Submission: Snowy 2.0 - Main Works EIS

Date: 6-November-2019

Re: Snowy 2.0 Pumped Hydro EIS (Application Number SSI-9687, EPBC ID Number 2018/8322)

Figure 6.4 Ravine Bay placement footprint and section

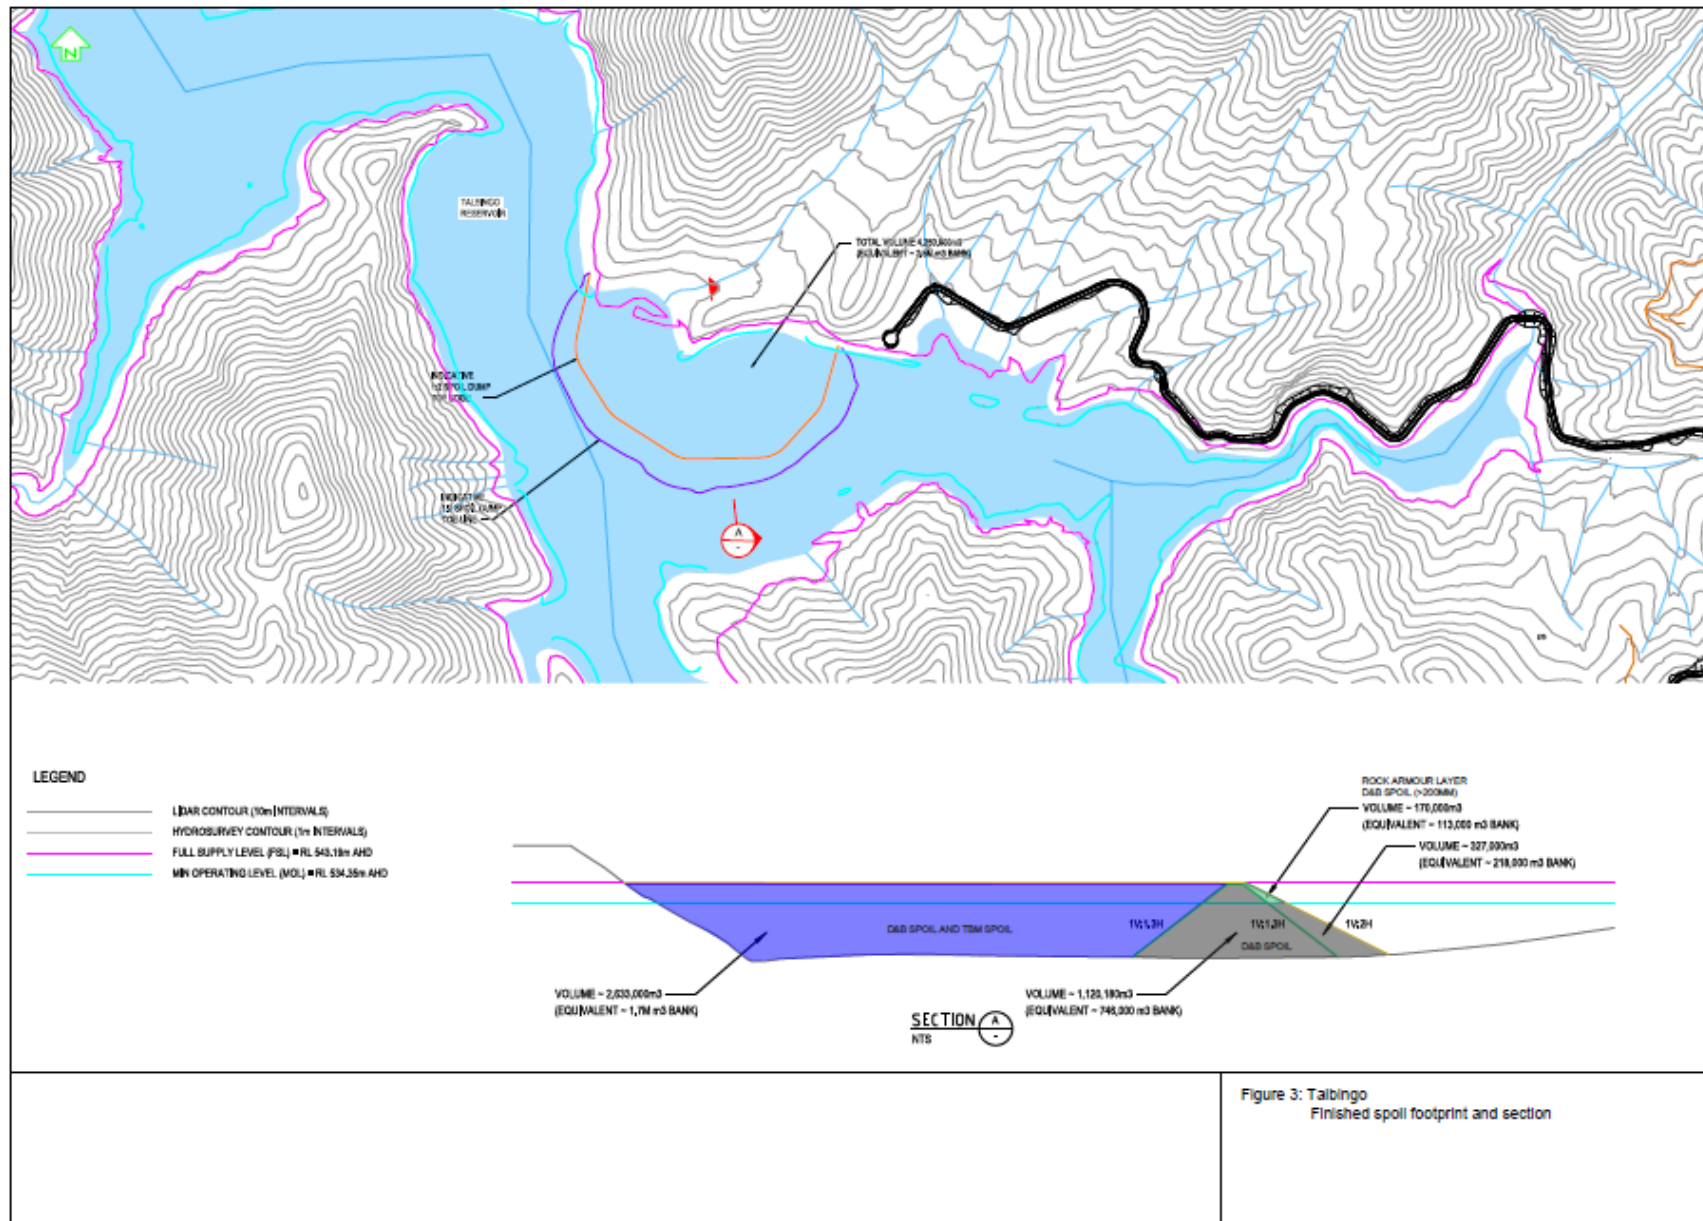
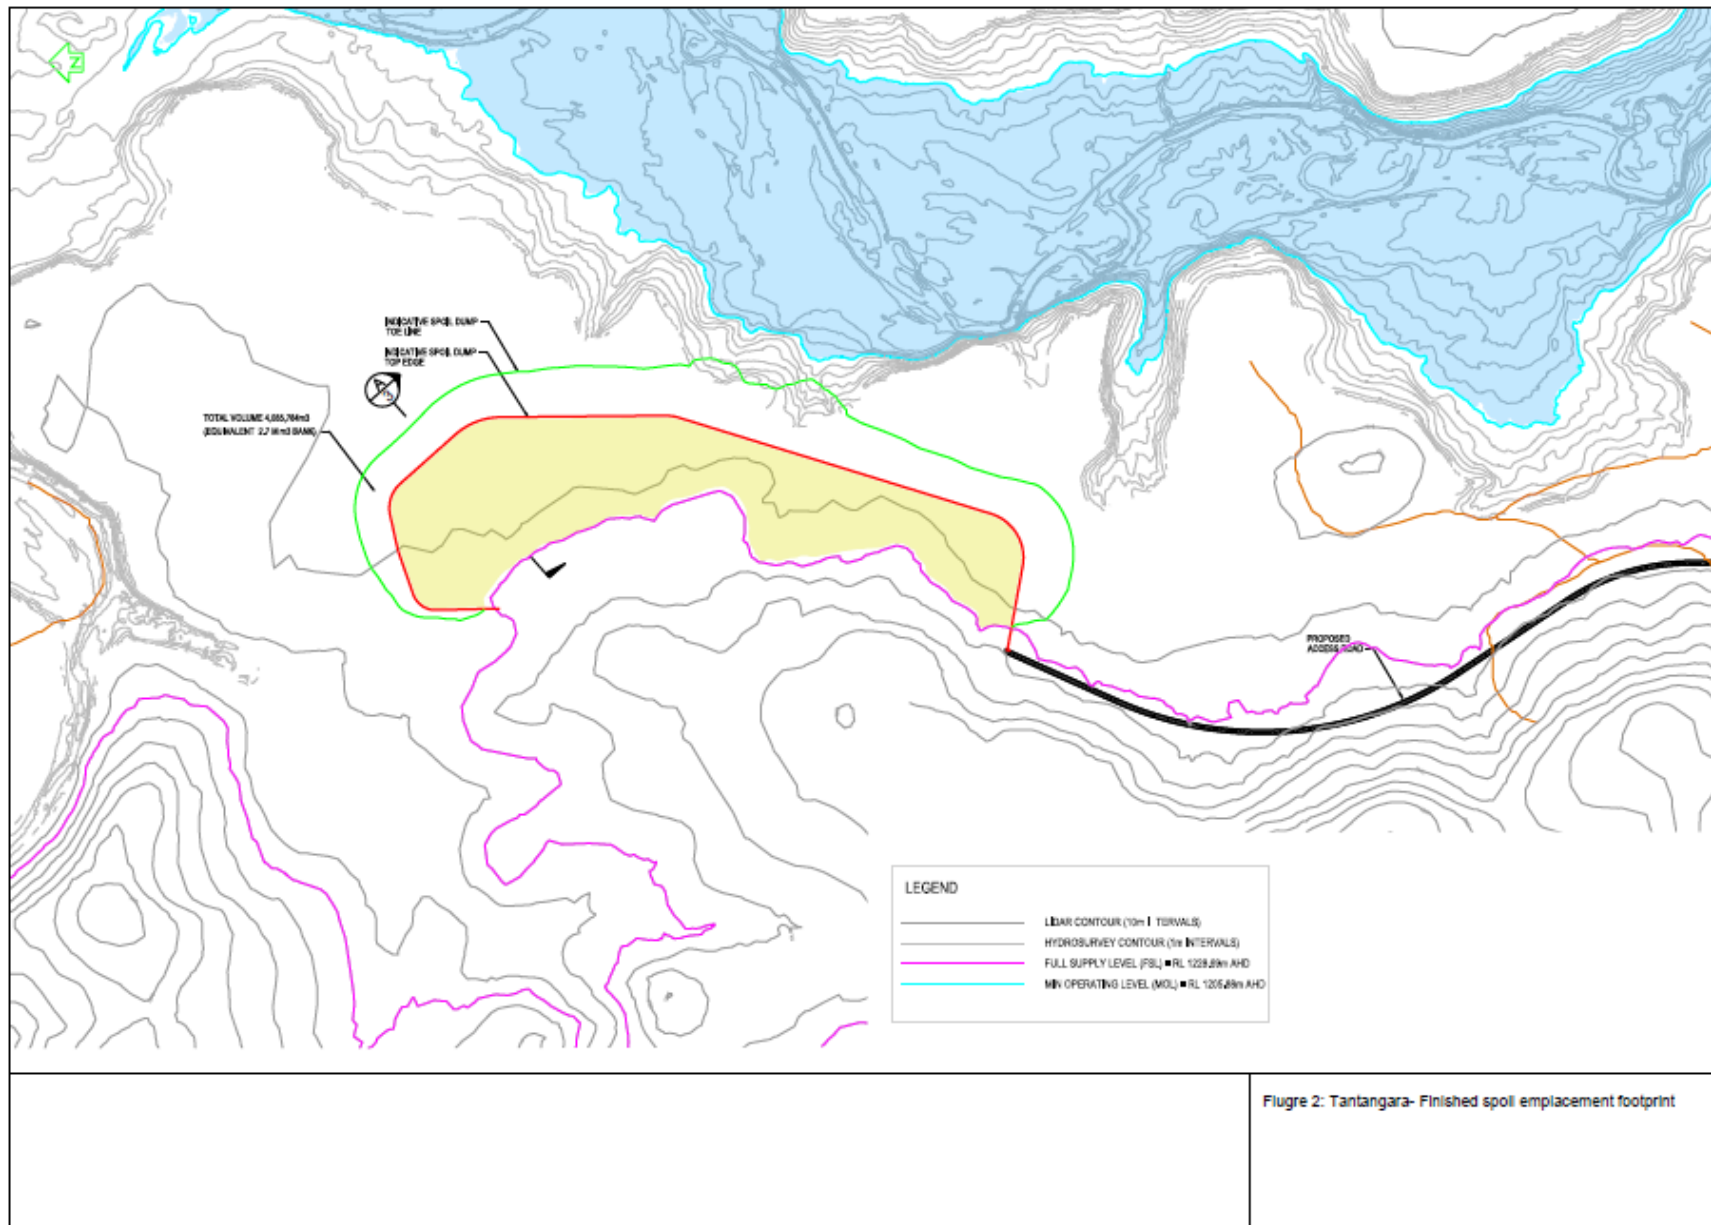
- Of note is the plan to emplace of tunnelling spoil, in respective reservoirs, with a significant exposed area designed to sit between MOL and FSL. Has consideration been given to design of emplacements extending above FSL, providing a smaller footprint, consuming less storage volume and avoiding the risk of cycling water levels (repeatedly exposing and inundating a significant exposed spoil area)
- We encourage consideration of minimising environmental impact with well designed, rehabilitated spoil emplacement options extending above FSL, noting that options that cap spoil just below FSL are likely to be exposed a significant proportion of the time and provide less options for rehabilitation
